STRUCTURAL
NOTE

C-1

358 Danforth Street, Portland, ME-Exterior Rear Deck-Revision

REAR ELEVATION/SECTION OF REAR DECKS 1
3/4" = 1'-0"

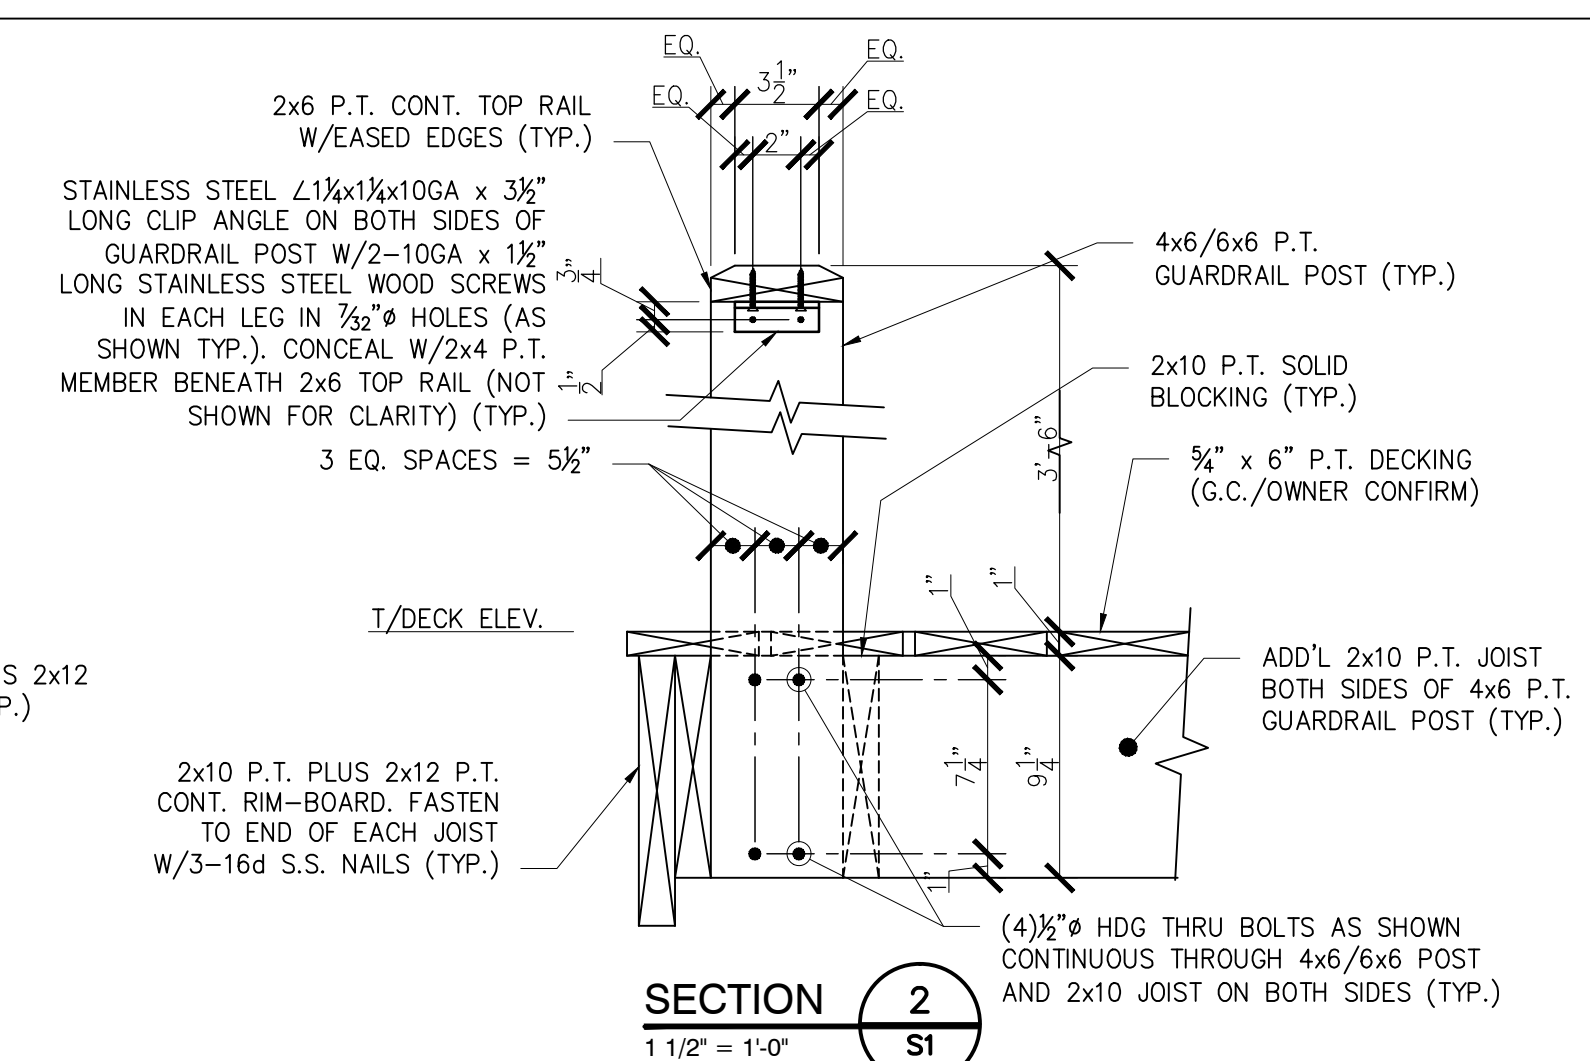
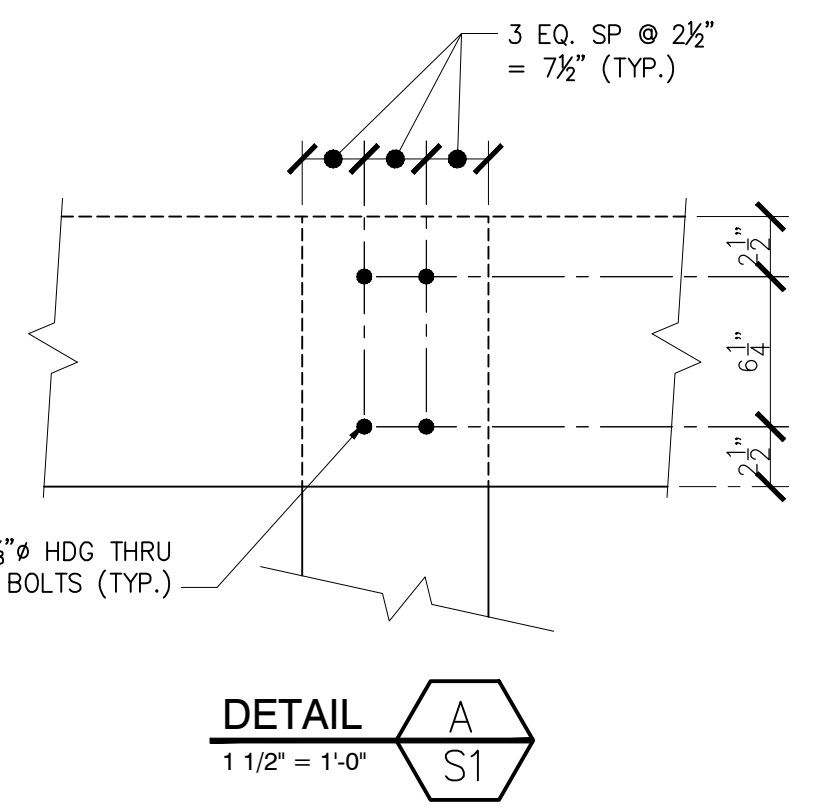
Please confirm that you have received this email correspondence as am not sure that this is the correct email address. As per your request, we reviewed the feasibility of revising the first floor (second level) deck from 15'-0" wide to 17'-0" wide which creates a 6'-0" cantilever (6'-7 1/4" from center of 8x8 post to north side of the deck) as opposed to a 4'-0" cantilever (4'-7 1/4" from center of 8x8 post to north side of the deck) indicated on the original design drawings. As we understand, the revision is to allow access to the existing window opening in the exterior masonry wall which shall become a door opening (without widening the existing masonry opening – please confirm) utilizing the existing lintel above the masonry opening.

The revision is acceptable as long as the 4-2x12 beam is continuous (approx. 17'-0" long) and the connection to the 4-2x12 beam to the northernmost 8x8 post is modified to include 6 - 5/8" diameter HDG (hot dipped galvanized) thru bolts as opposed to 4 thru bolts indicated on the original design drawings by installing a third set of two thru bolts at the center of the 6 1/4" dimension shown in Detail A/S2. There shall be additional 2-2x10 @16" o.c. long span joists and additional ledger against the existing masonry wall installed to support the additional 2'-0" of deck. In addition, the spacing of the guardrail posts on the eastern edge of the first floor (second level) deck shall be revised to 5'-8" maximum spacing (as opposed to 5'-4" maximum) to create three wider spaces. All remaining structural components are acceptable as indicated or shall be modified as indicated on the original design drawings.
